SSD 8980 Bowral & District Hospital Redevelopment - Response to Submissions Table (Public)

Bowral & District Hospital Redevelopment
Landscape Design Development

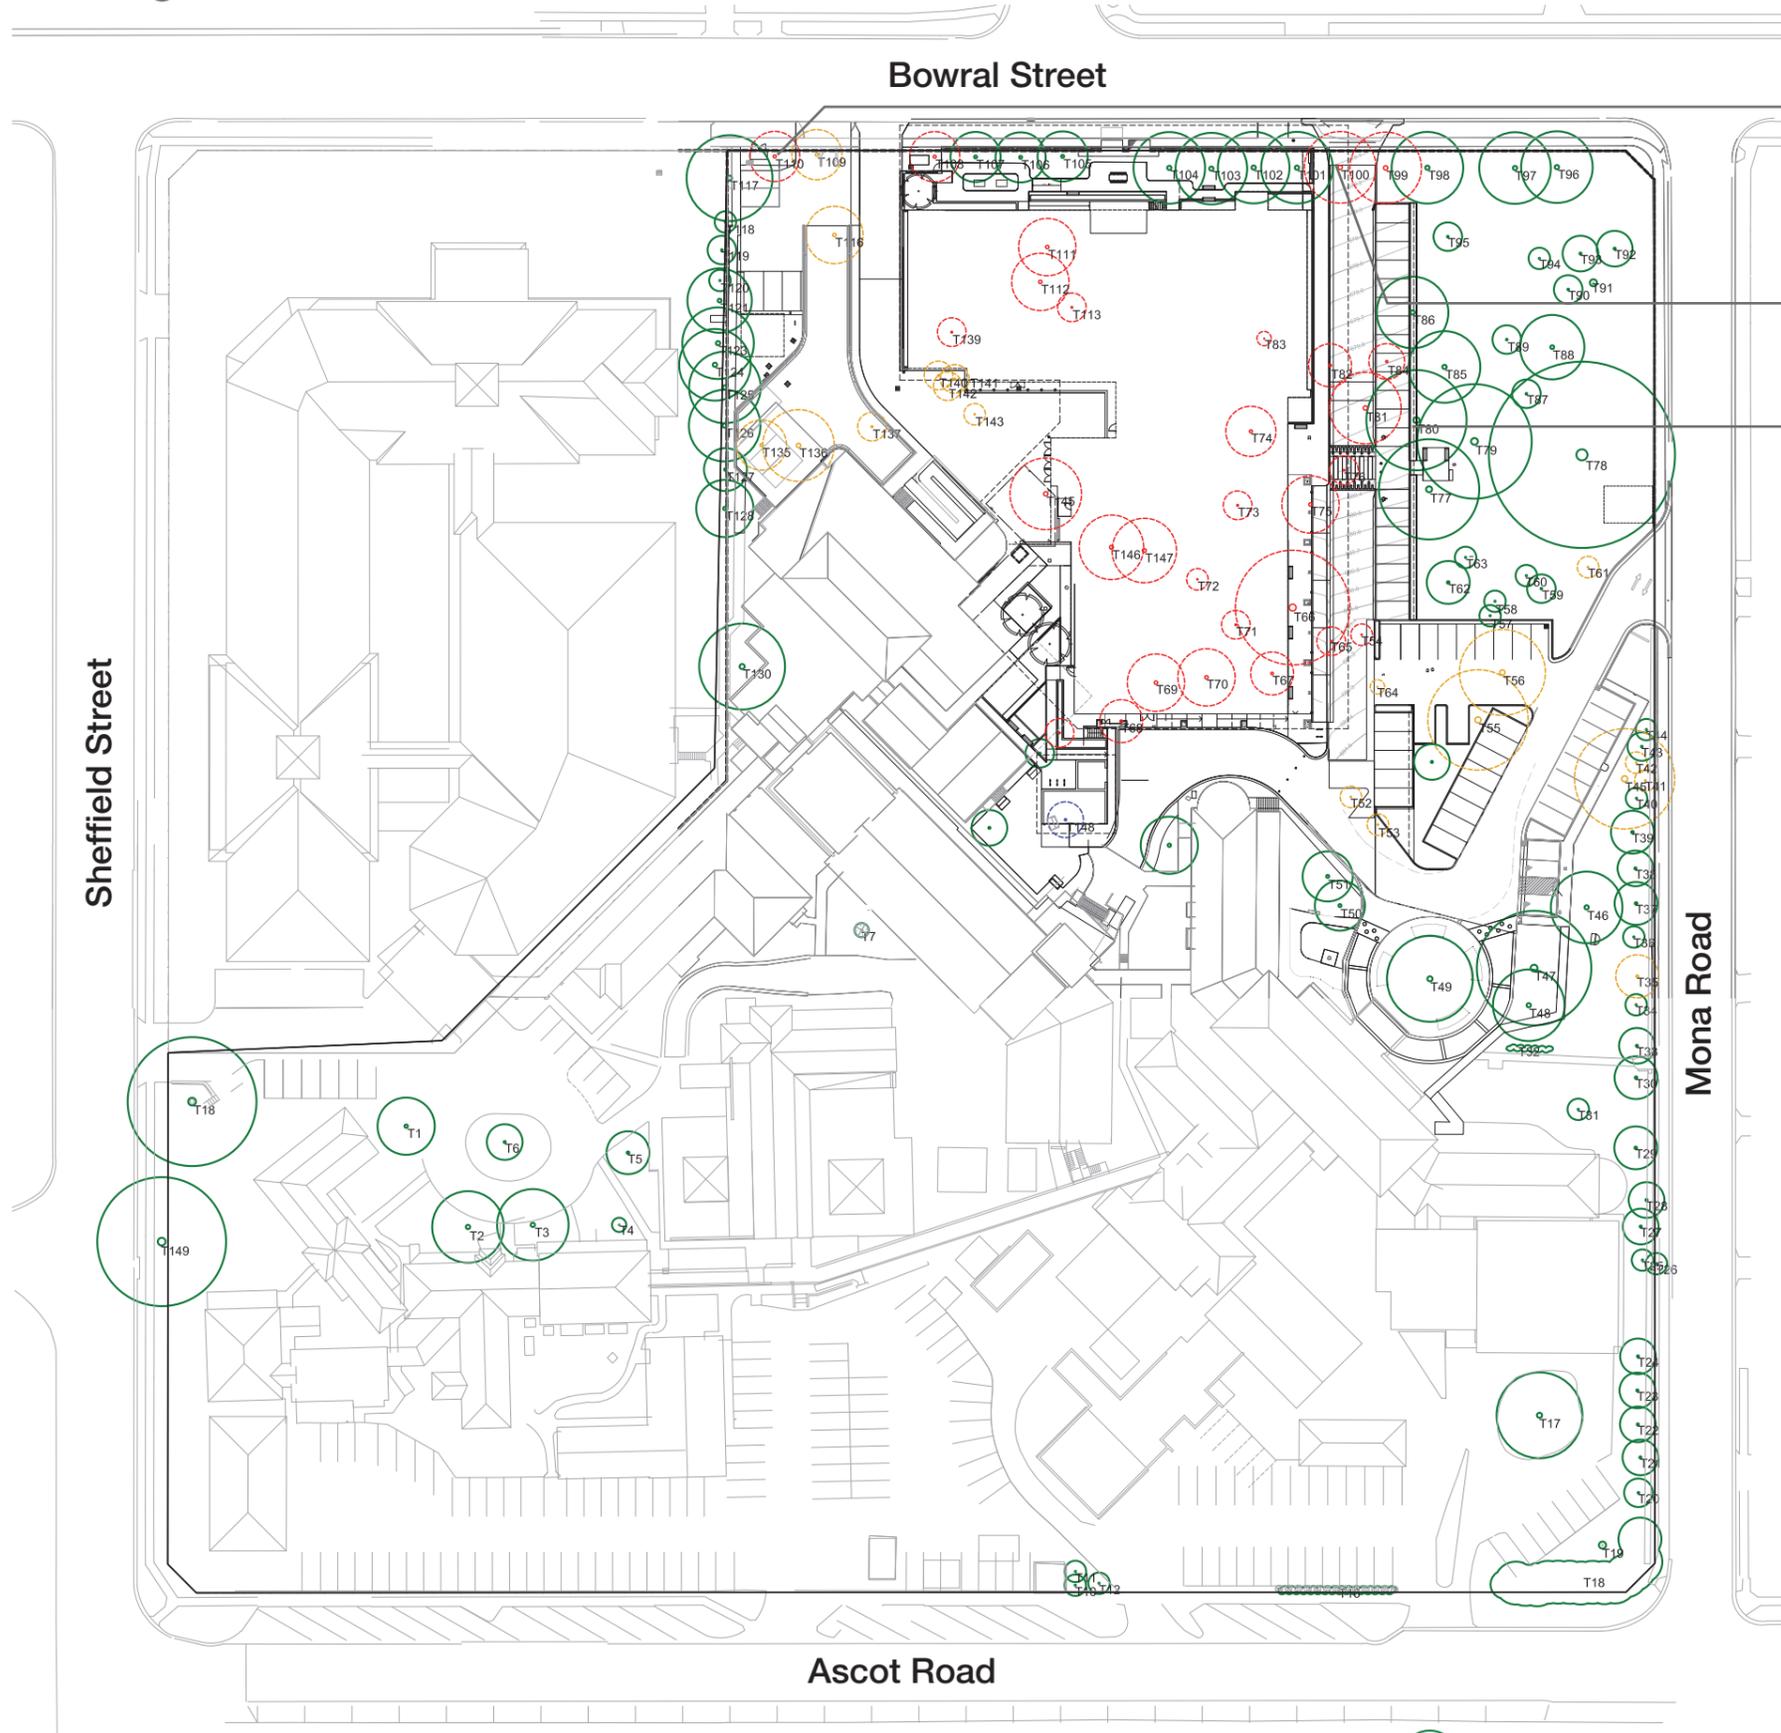
<p>3.13 • Landscaping and Trees: Although it may be true that the SSDA works will require only one tree to be removed, this is an intentionally misleading statement because the Landscaping Plans (Appendix 12) show there were/will be approximately 30 trees of various sizes removed in the Early Works, many of which were not required to be removed for the Early Works themselves, but to clear the site for the CSB works. The Landscape Plan shows three more that are likely not to survive.</p>	<ul style="list-style-type: none"> • The proposal requires minimal tree removal, all trees which either have been or will be removed will be replaced by a suitable replacement planting.
